4th July 2024

RESERVED MATTERS PLANNING APPLICATION, REFERENCE H09-1044-23, ERECTION OF 285 DWELLINGS INCLUDING PARKING, PUBLIC OPEN SPACE, DRAINAGE, INFRASTRUCTURE, LANDSCAPING, ACCESS, APPEARANCE, LAYOUT AND SCALE (PHASE 3) - OUTLINE APPROVAL H09-0521-14 AND RE-SUBMISSION OF H09-0845-22 AND H09-1118-22.

PROJECT:	Proposed Residential Development at Holbeach Meadows
DRAWING:	Site Sections Phase 3 - Northern Site Plots (163 No. Plots)
SCALE:	AS SHOWN @ A1
DRAWN:	GB
DATE:	NOVEMBER 2023
REVISION:	A
DRAWING No:	137-SS-15

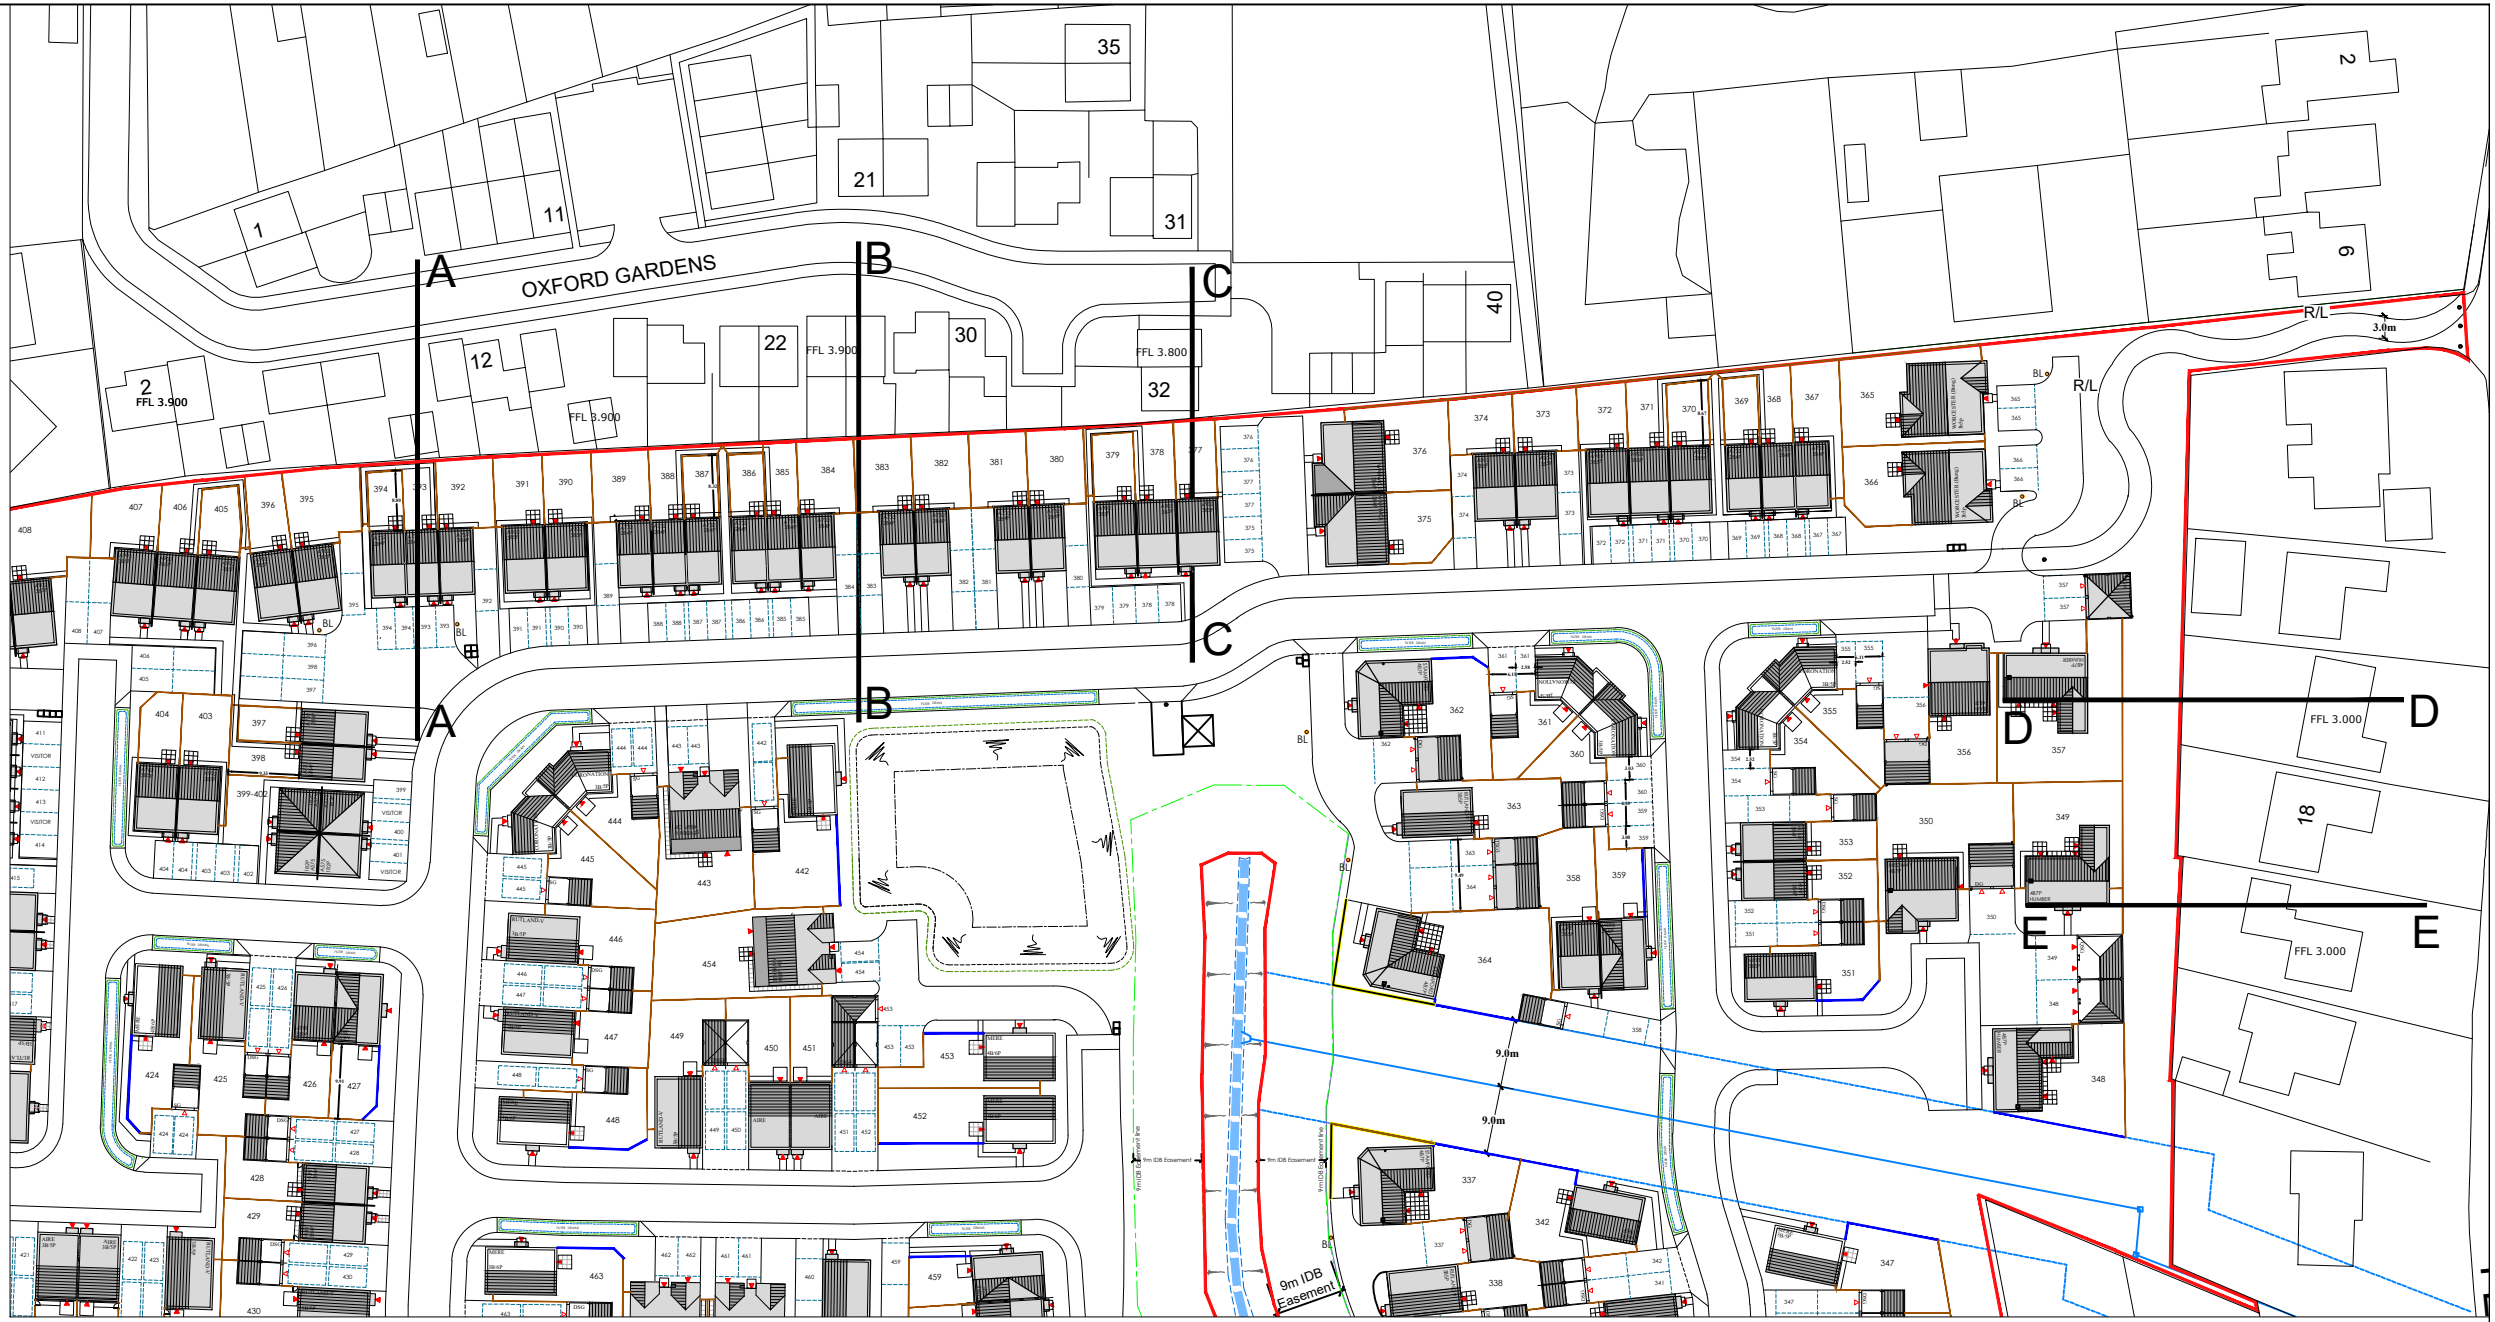
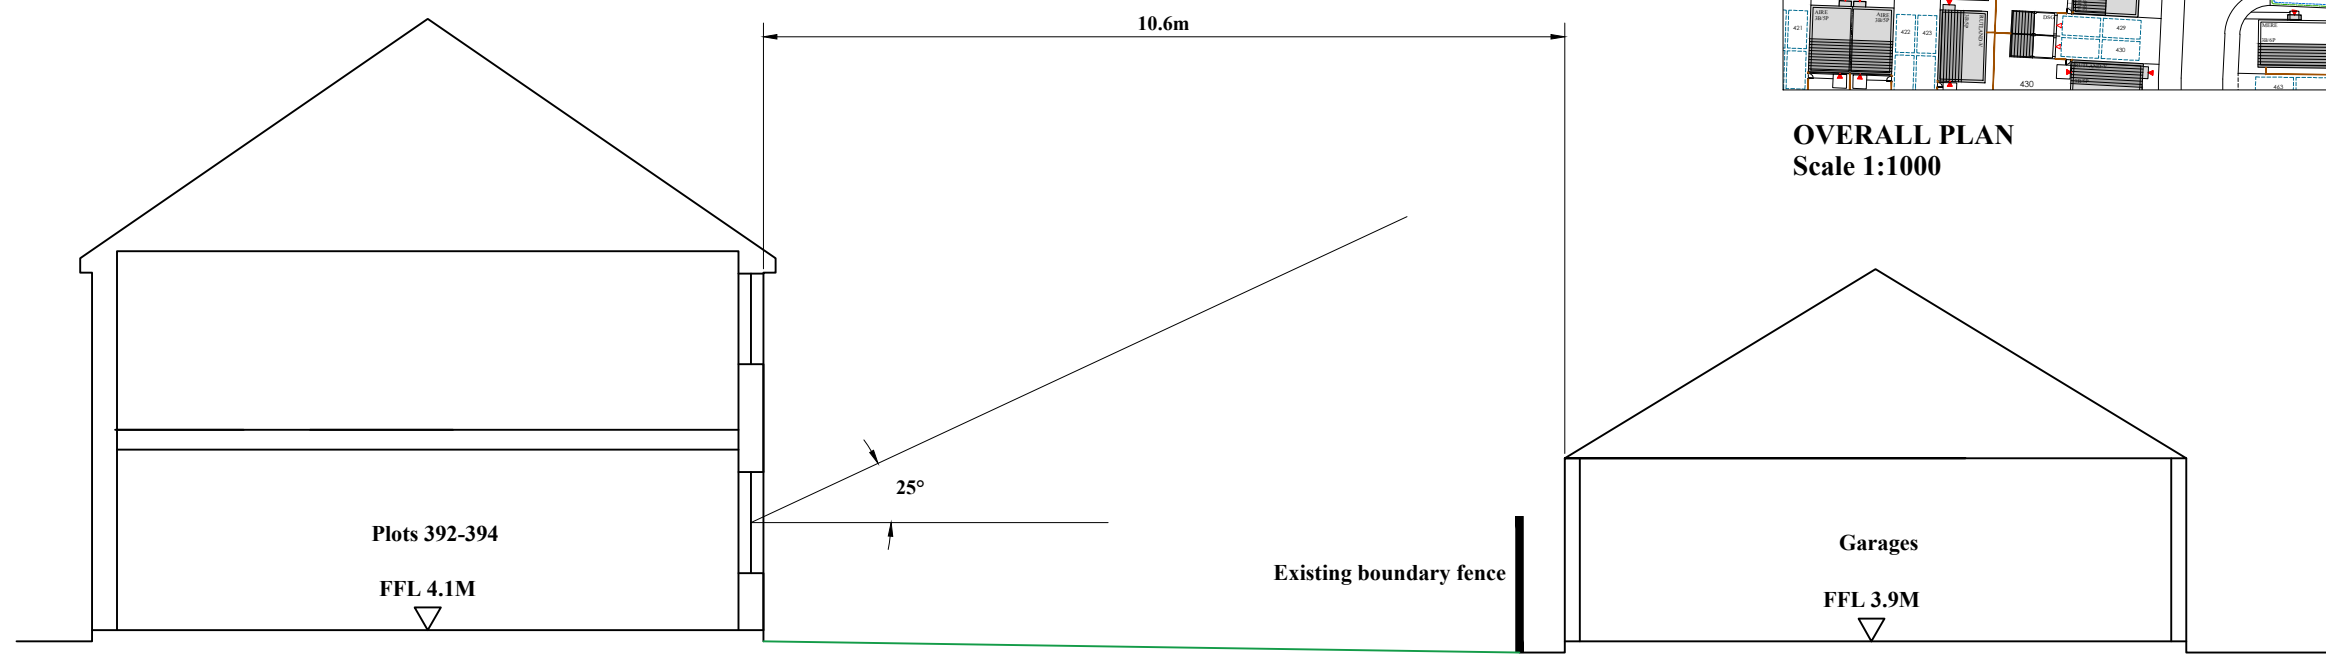
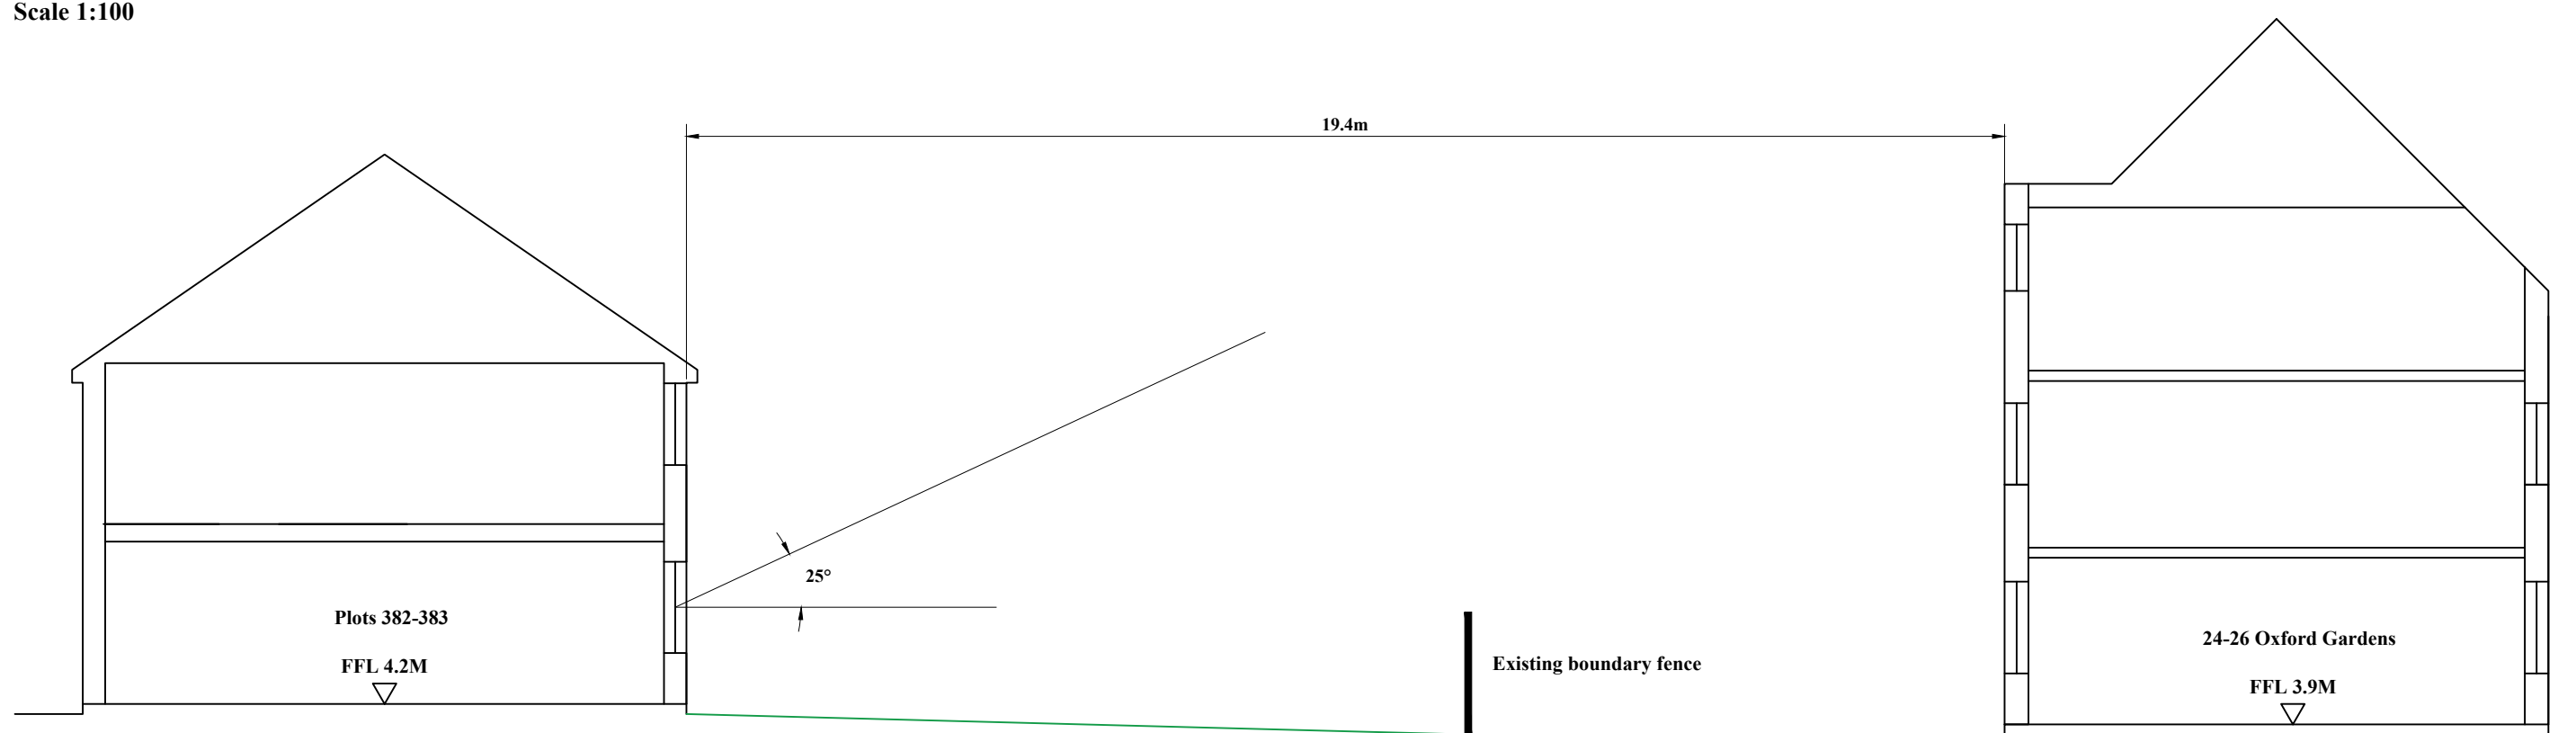
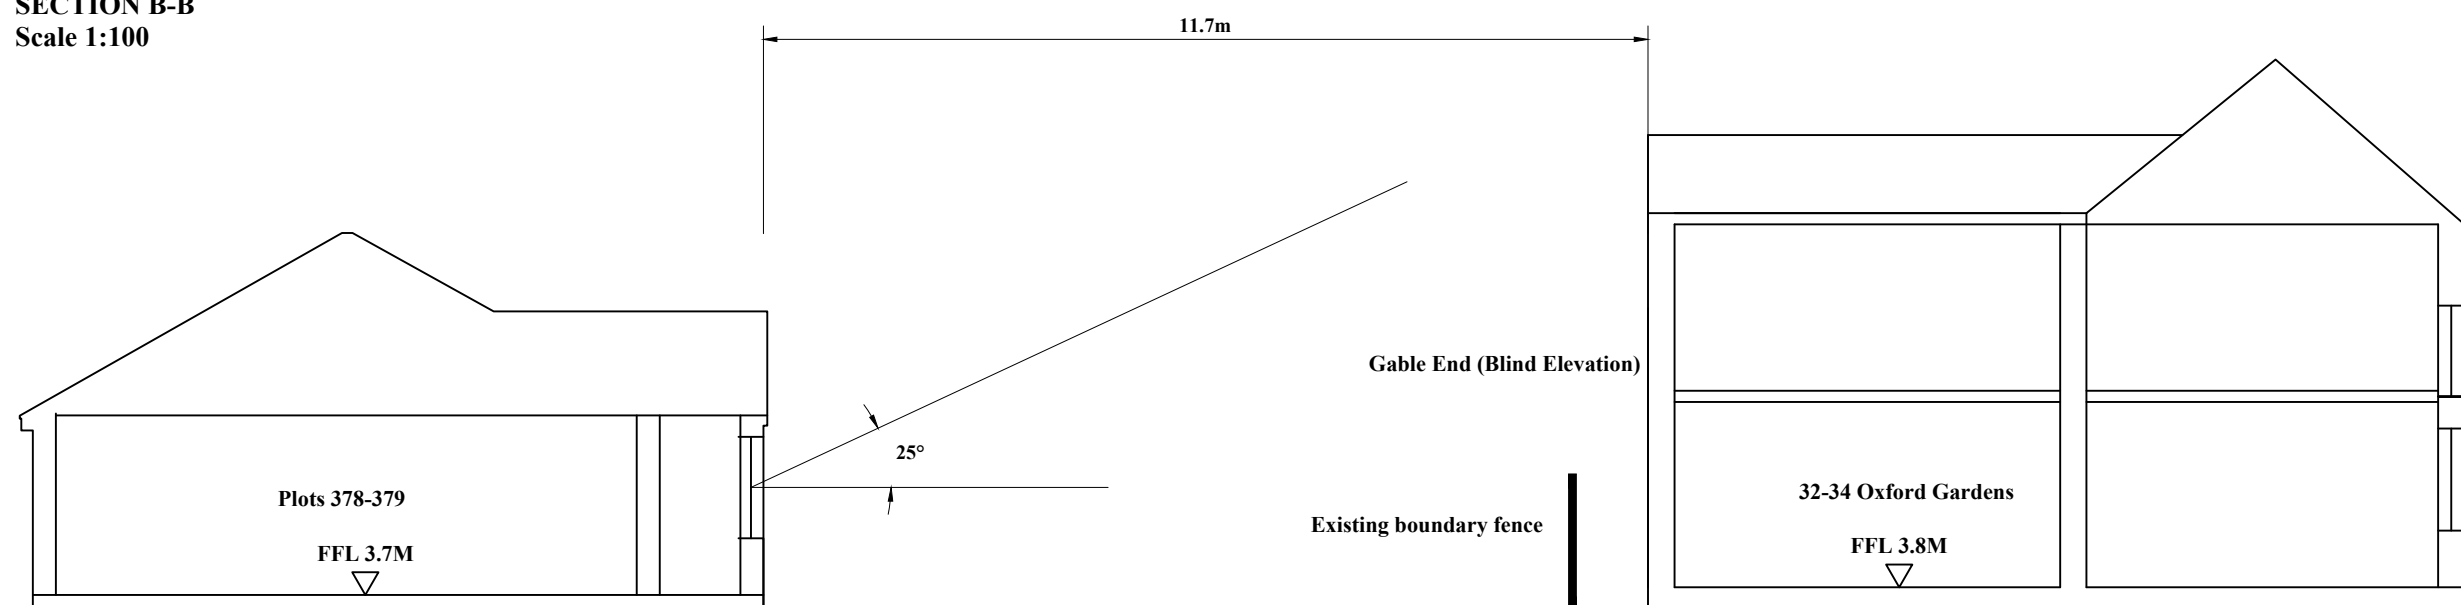
4. To address concerns over the position of plot 442 and its proximity to the SUDs attenuation basin, we have provided a further section to show the gently sloping sides of this feature and the fencing which separates it from plot 442. As you know, the attenuation basins are 'off line' and will only hold water temporarily during extreme weather events.
